Our Ref: LU/54/17/HH

**Town & Country Planning Act 1990 (as amended)
Town & country Planning (Development Management Procedure) (England) Order 2015
Application for Householder Planning Permission**

Development Proposed extension
Location 5 Camelia Close Littlehampton

Itemref	Quantity	Title/Name, designation, material, dimension etc	Article No./reference
Designed by	Checked by	Approved by - date	Date
			December 2016
			1:200/1:1250
5 Camilia Close		Proposed Extension	
	03		Edition Sheet

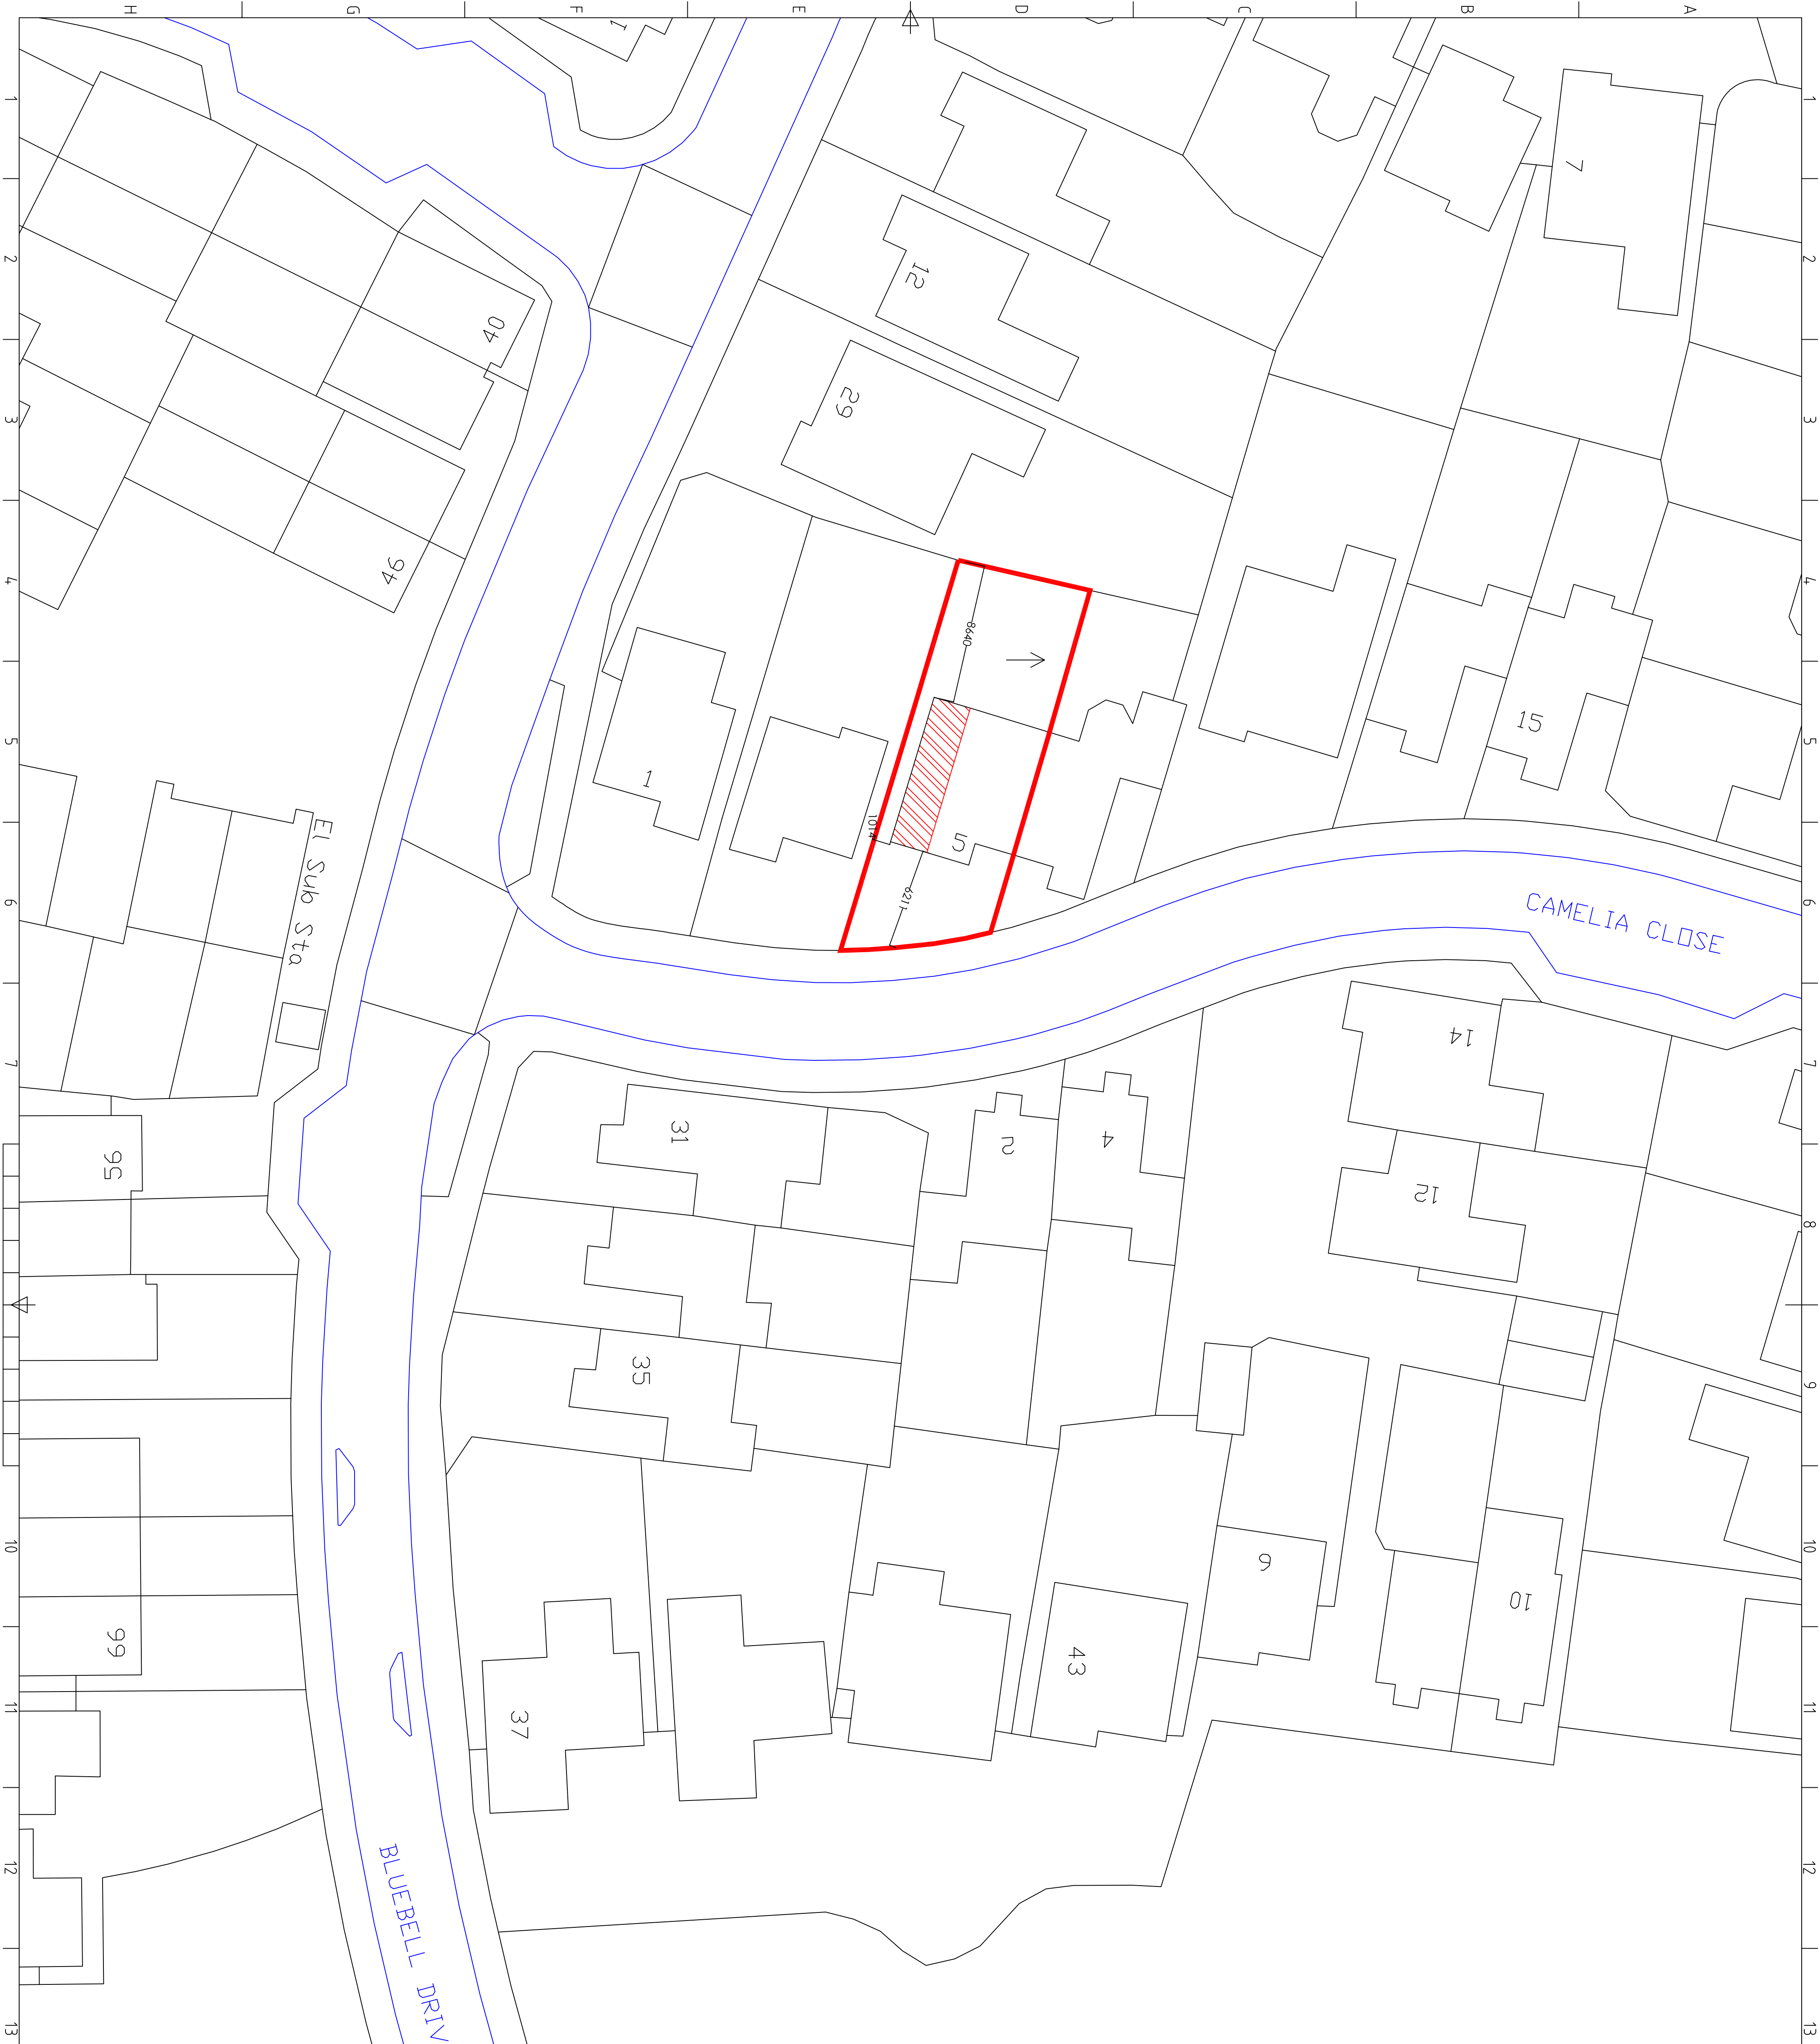
Apologies for the delay in responding to you. The area of the extension is required to be highlighted on the block plan so it is clear where the extension actually is. In this case it will be hatched on top of the existing footprint where the first floor extension is situated. Please amend your block plan.
